CITY OF ALBUQUERQUE

August 28, 2017

**Re: Sonic 8th and Bridge
Erosion and Sediment Control Plan
Engineer's Stamp Date 6-28-17 (L14E025A)**

EROSION AND SEDIMENT CONTROL PLAN

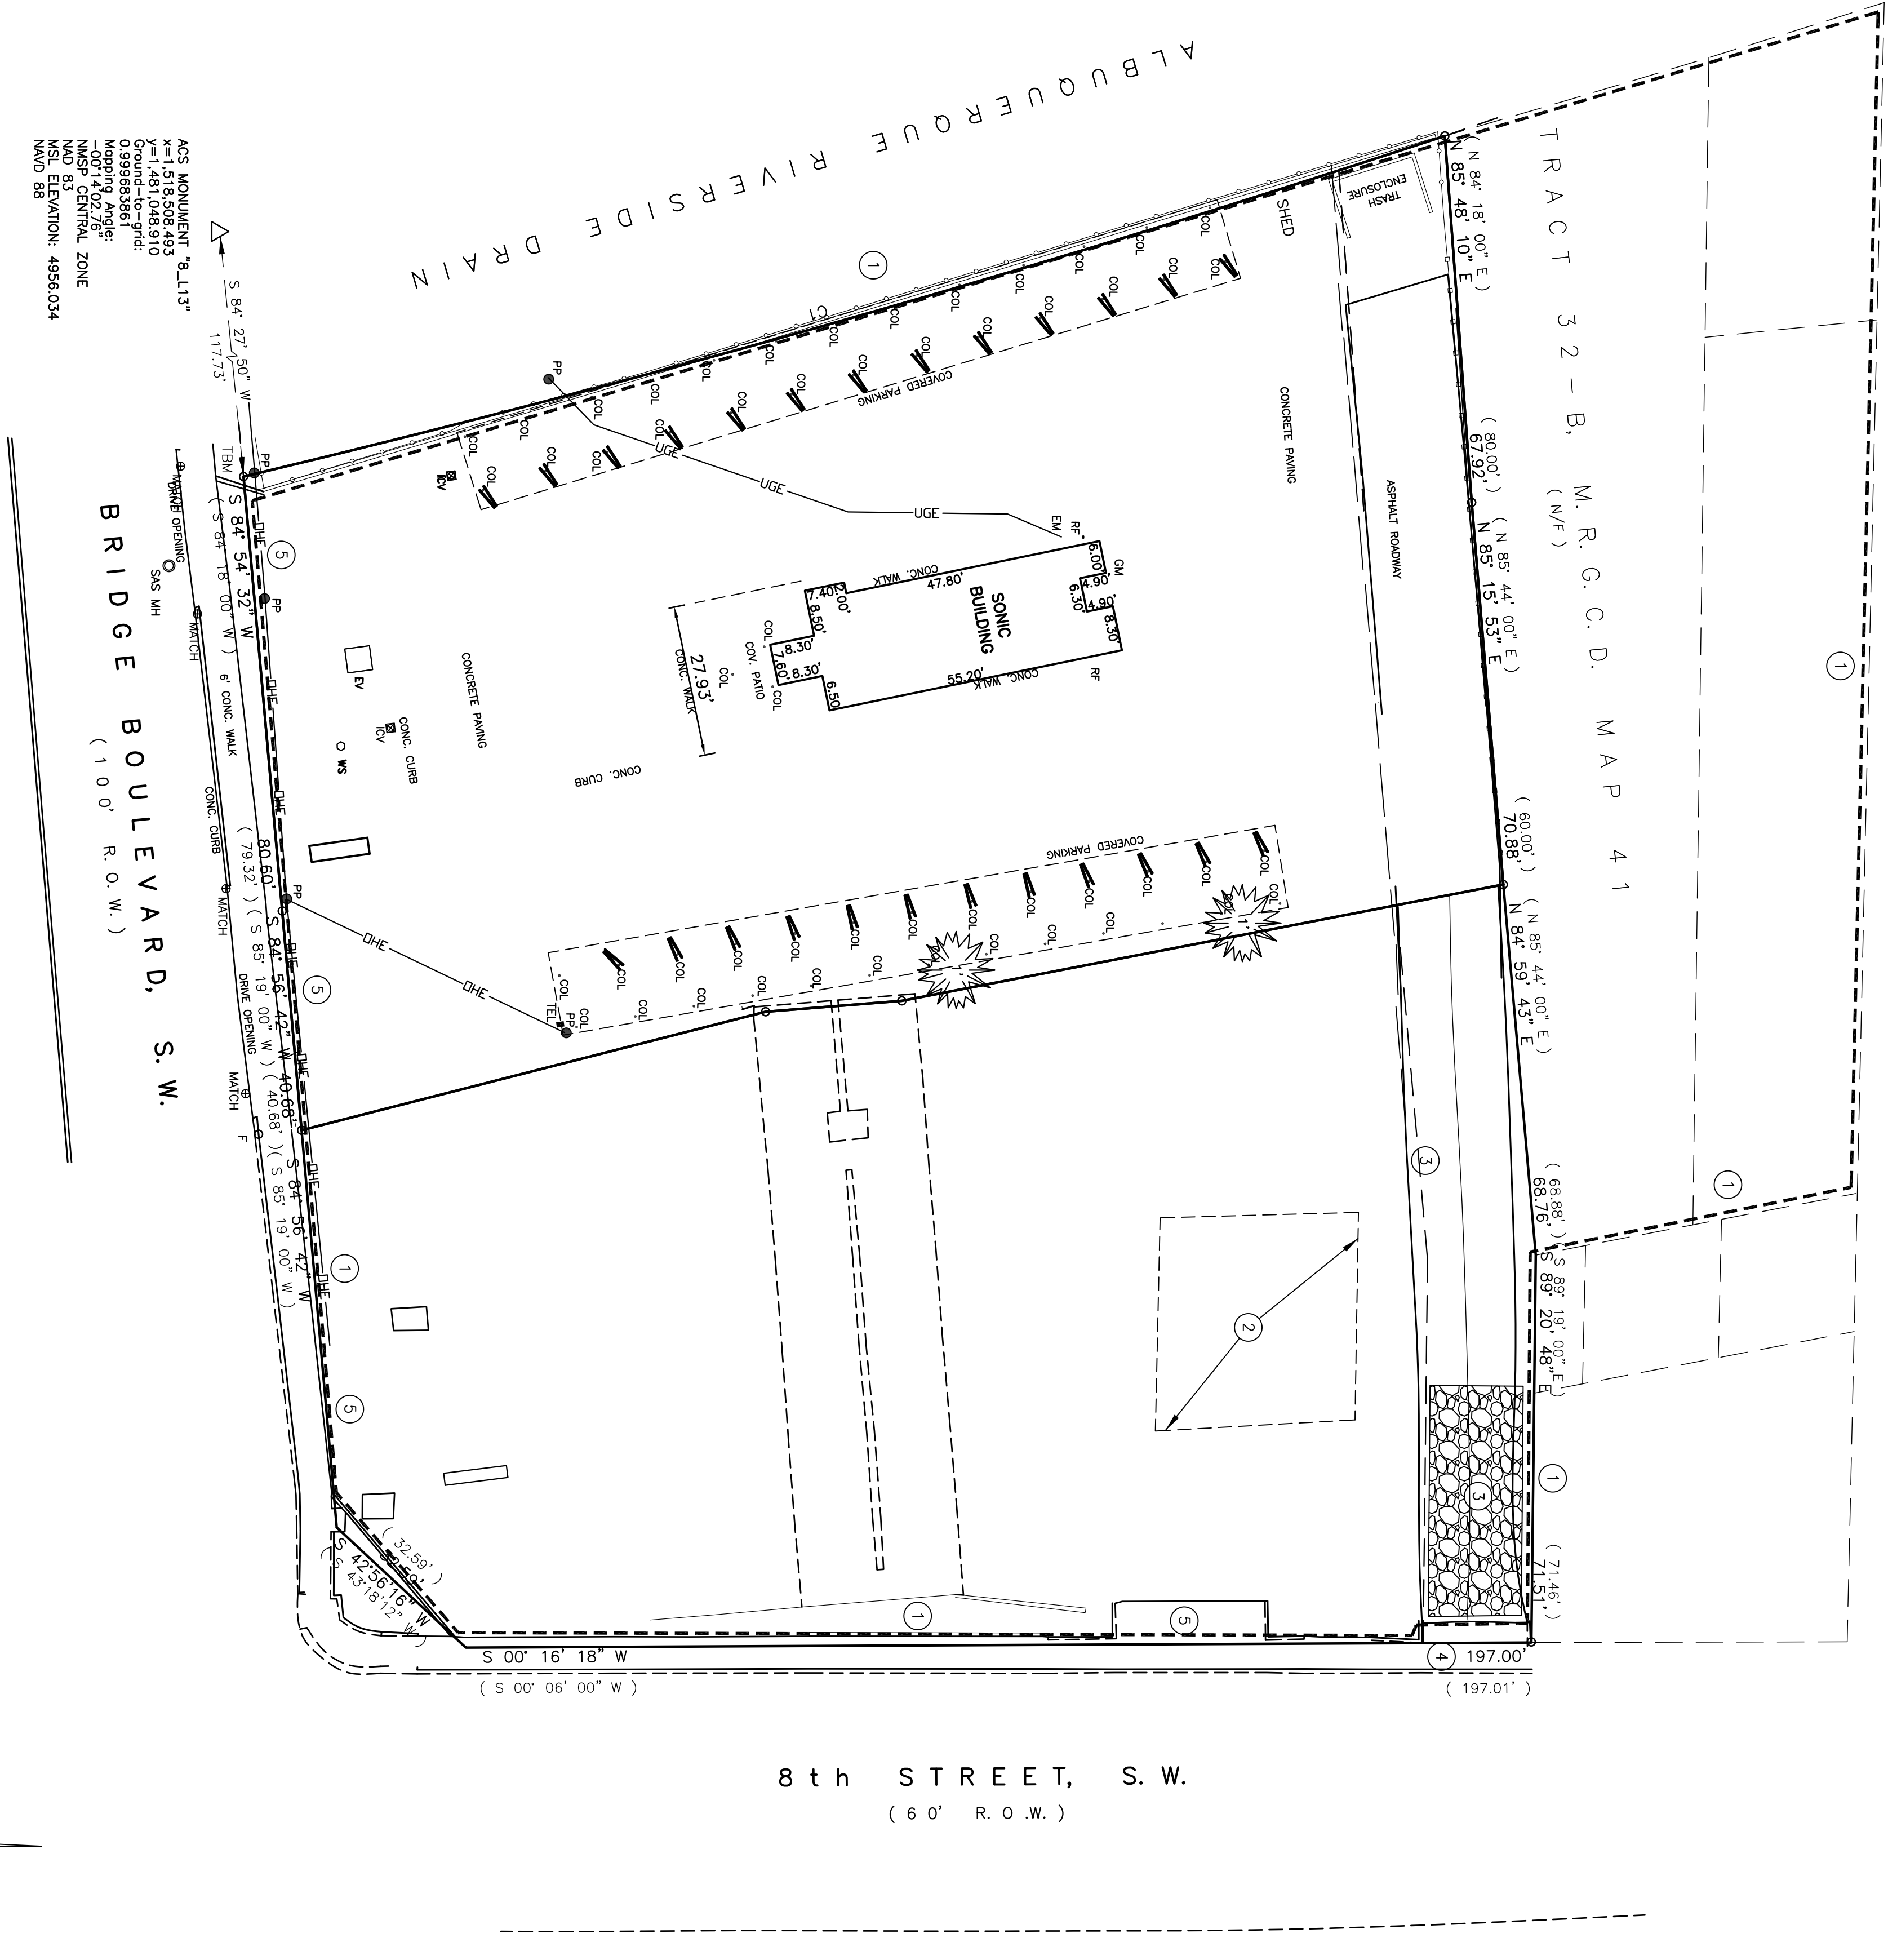
1. Provide existing and proposed topography.
2. Provide the drainage outfall location(s).
3. Provide a detail for each BMP proposed.
